KIRKLEES METROPOLITAN COUNCIL INVESTMENT & REGENERATION SERVICE

DELEGATED DECISION FOR DISCHARGE OF CONDITION A.4 - NOTIFICATION OF A PROPOSED ENLARGEMENT TO DWELLINGHOUSE

Reference no.	2026/HH/91607/W
Site Address	36, Moor Park Avenue, Beaumont Park, Huddersfield, HD4 7AL
Description	The proposal is for erection of single storey rear extension. The extension projects 4m beyond the rear wall of the original dwellinghouse. The maximum height of the extension is 3.5m, the height of the eaves of the extension is 2.5m
Recommending Officer	Morgan Braithwaite

DECISION – PRIOR APPROVAL REQUIRED AND REFUSED

DRAWING TITLE
Proposed Plans

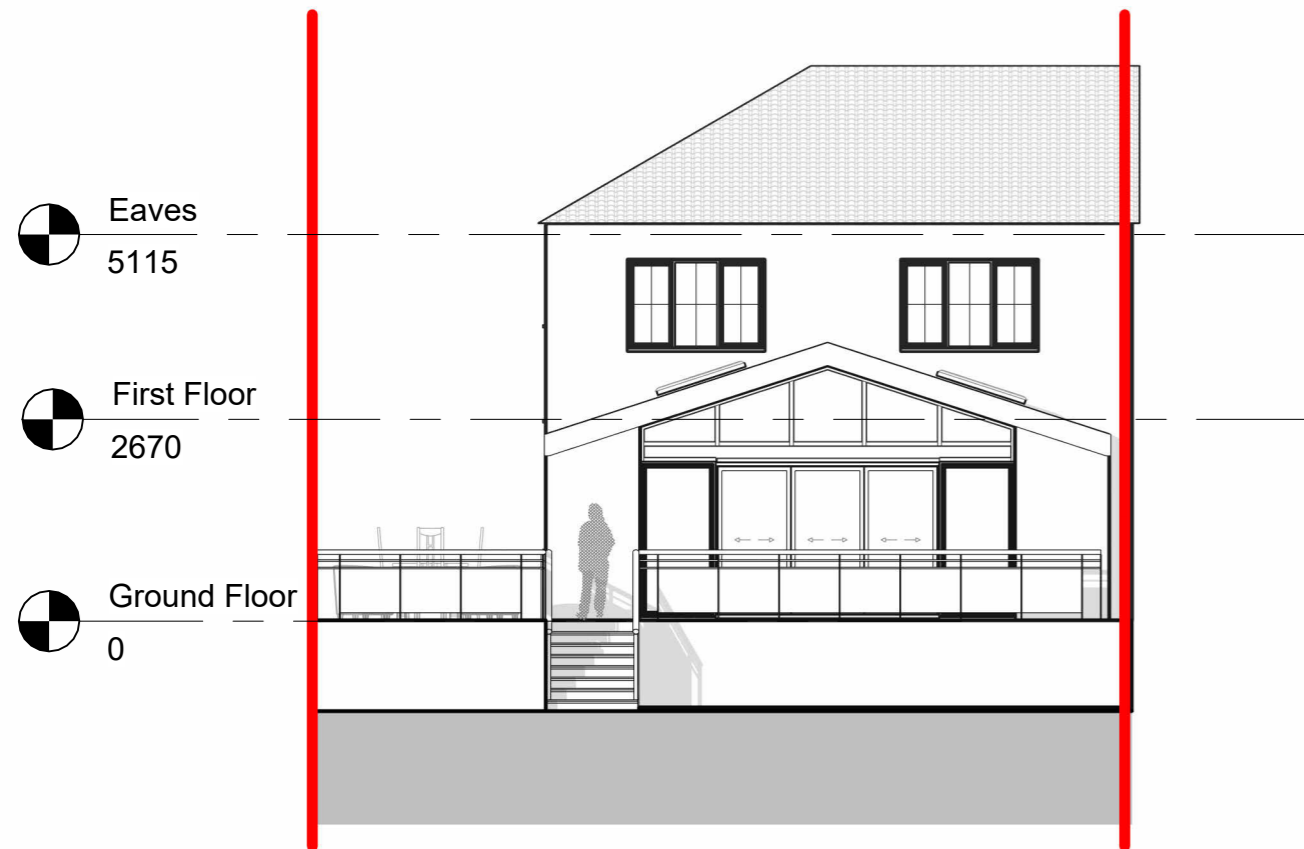
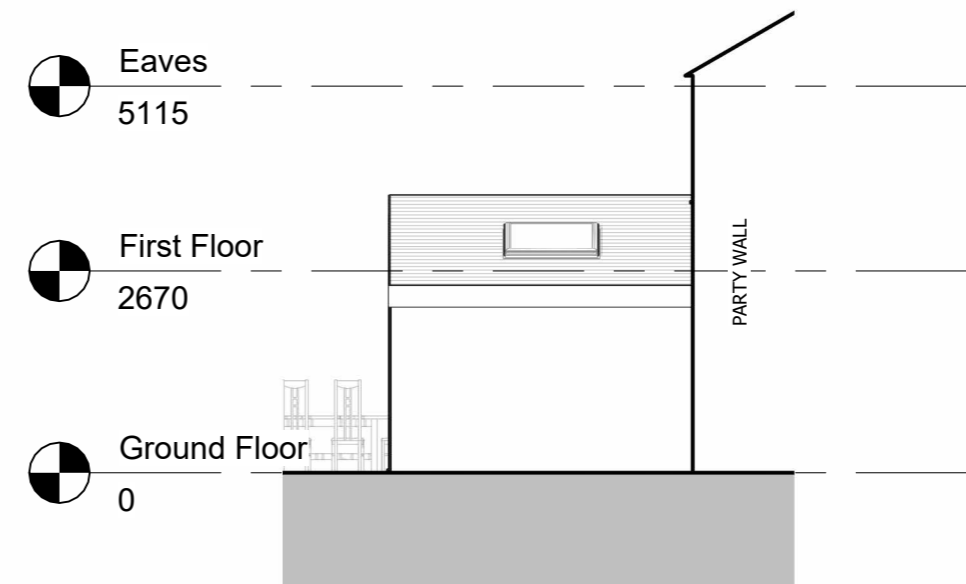
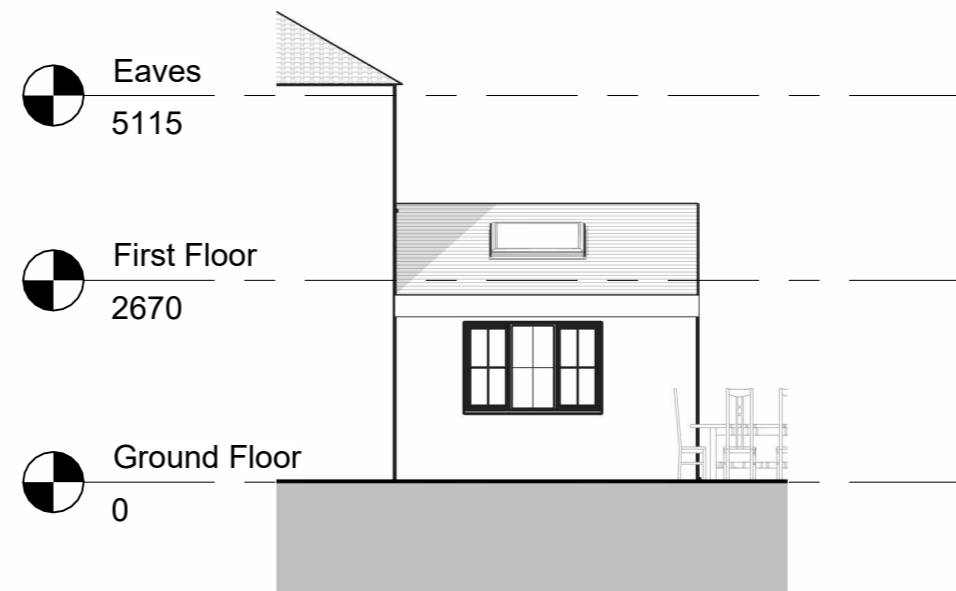
Objections have been received in relation to overshadowing and overbearing impact. When considering the SPD paragraph 5.6, it states that rear single storey extensions should not exceed 4m in height nor project more than 3m from the rear wall.

In the case of the proposal, the extension would be no more than 4m in height and would extend 4m along the boundary. It is acknowledged that the Permitted Development Order permits an extension beyond 3m in length although it is considered this only establishes the principle of a 4m extension in so far as amenity principles are considered acceptable. The extension is proposed to be constructed along the shared boundary of the properties; however, it is unlikely this would result in the removal of the existing boundary treatment which provides partial screening. Given these factors, it is considered that the proposed development would result in a significant impact on the shared boundary which is considered to result in an unduly overbearing and oppressive impact on no.83.

In addition, when considering SPD paragraph 4.17 in which the impact of overshadowing on neighbouring properties is assessed with regard to 45 degree guidelines. In this case, the 45 degree line from the nearest habitable window of no.38 would not be achieved following the proposed extension. It is therefore, considered that the proposed development would cause detrimental harm to the level of natural ambient light currently received at 38, Moor Park Avenue.

As no.38 adjoins to the north, it is concluded that the proposed development would result in significant overshadowing on the rear amenity space and is considered to have an unacceptable impact upon the amenity of the occupiers of this dwelling.

By virtue of its size, scale, projection, proximity to the shared boundary and massing the proposed development would cause an unacceptable degree of harm to the amenity of the occupiers of the adjacent property by reason of leading to overbearingness on the shared boundary, loss of light and overshadowing. The development would cause an unacceptable level of harm to the amenity of neighbouring occupiers contrary to policy LP24 of the Kirklees Local Plan, principles within the Council's adopted House Extensions and Alterations SPD and policies within Chapter 12 of the NPPF.
